David M.Y. Millikan, P.E.

May 22, 1989

Re: Roof Drain Modifications

Enclosed are six sets of the revised drawing sheets C-1, C-2 and C-3 for the Banquest Building at 111 Lomas. The location of discharge for the roof drains from the tower to the Lomas Boulevard right-of-way have been changed to reflect the actual field conditions.

SIDEWALK CULVERT DETAIL
NO SCALE

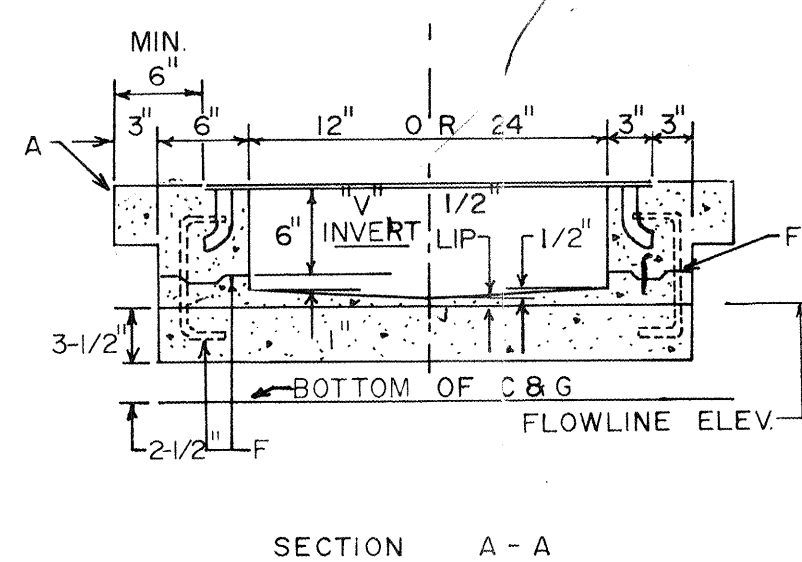
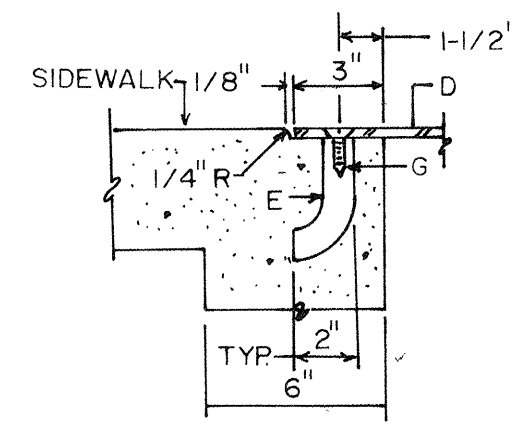
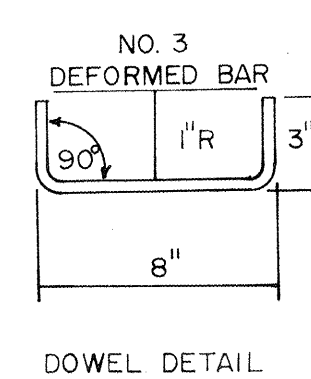
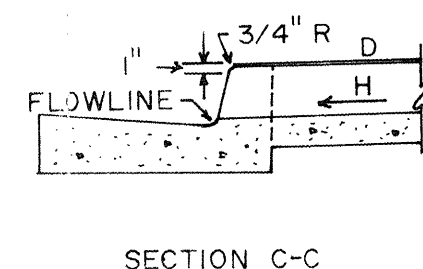
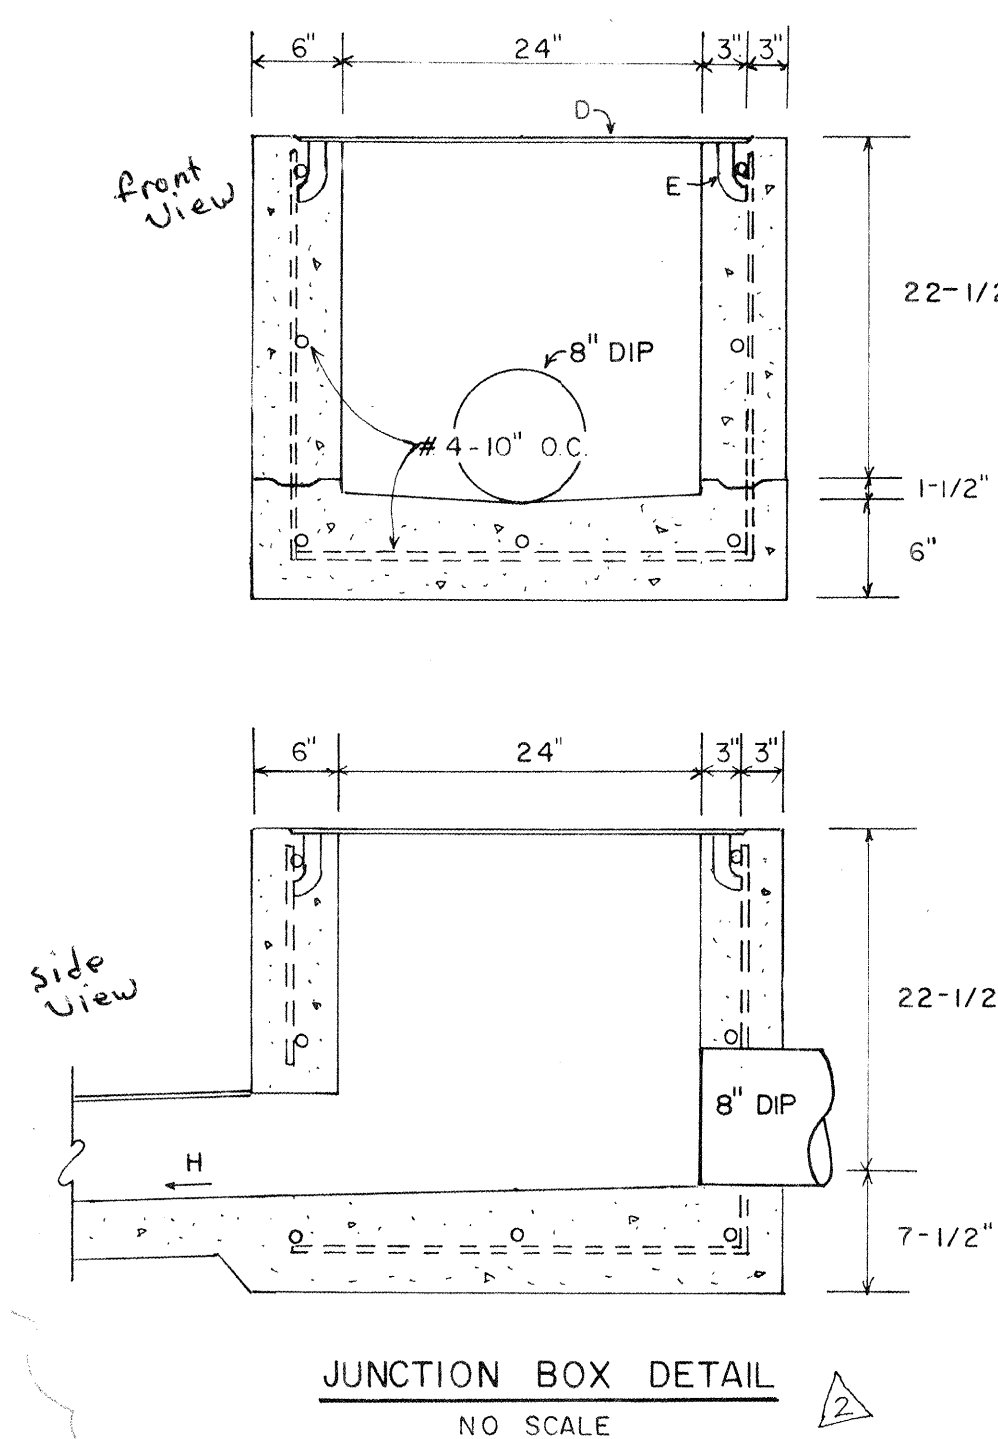
The reduction in outlet size from 12" to 8" has been made based upon the information which you obtained from the plumbing engineer. This size reduction is acceptable to Bernie Montoya at the City Hydrology Department. As you can see, a special junction box and use of the sidewalk culvert are specified. These items have been discussed with Bernie and are acceptable.
